City of Albuquerque Stormwater Construction Site Inspection Report

Project Name:		Monterey Place Apartments					
Location:		2306-2320 Central Ave SW					
Site Contact Name & Agency		James Mathews - Pacificap		ESC File No.		J12E030	
		jmathews@pacificap.com		NPDES Id. No.			
Inspection Date:		02/19/20		Start/End Time:		0825/0900hrs	
CoA Stormwater Inspector:		Timothy E. Sims					
Construction Phase:		Demo					
Type of Inspection:	x	Regular	Storm Event	Post Storm Event >0.25"	311/Complaint	Follow Up

STABILIZED CONSTRUCTION ENTRANCE

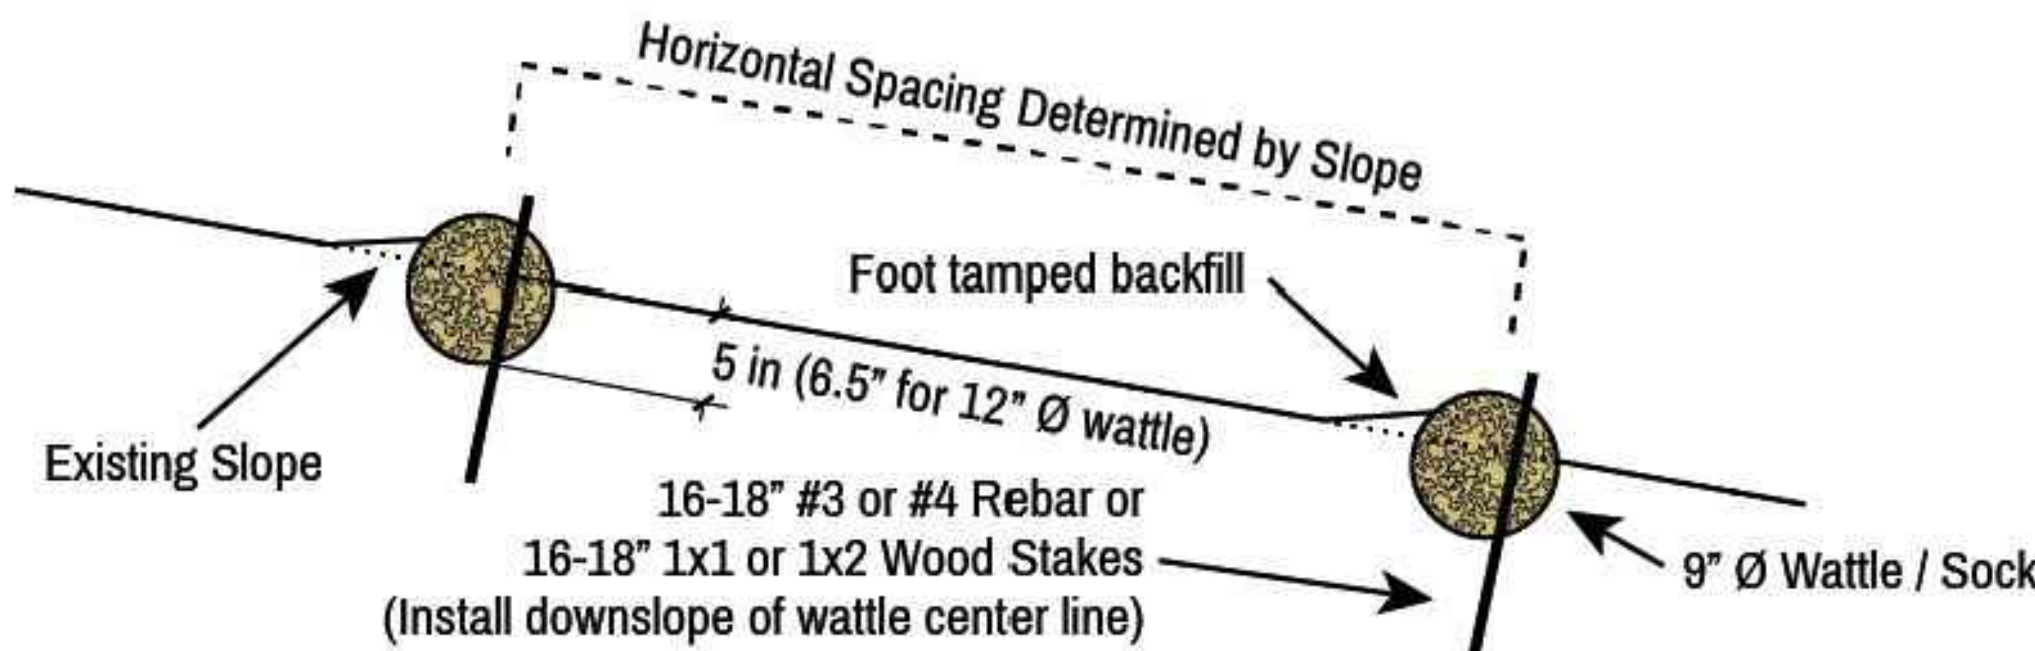
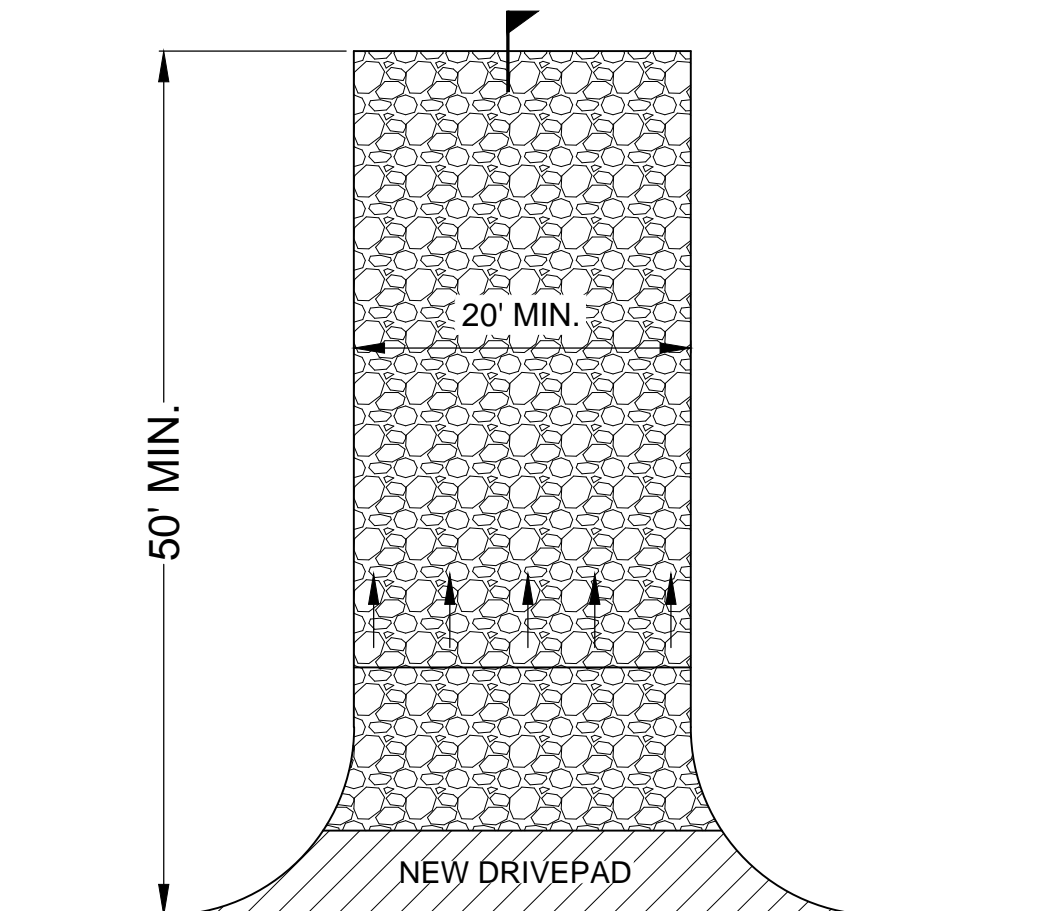
Item Number	Deficiency/ Corrective Action		
1	Provide NPDES posting for this site. (either NOI or Low Erosivity Wavier, LEW)		
2	Track out pads requires installation		
3	Sediment BMP's along the northside fronting Central require installation. A mulch sock can mitigate this issue.		
4	Please provide the initial SWPPP self-inspection report. This determines the start date to assist with the LEW time frame.		
5	Please provide an approved ESC Plan.		
2.1	Discharge off site? (Y/N)	No	
4	Self Inspection Reports	requested	Latest report Date: not on file
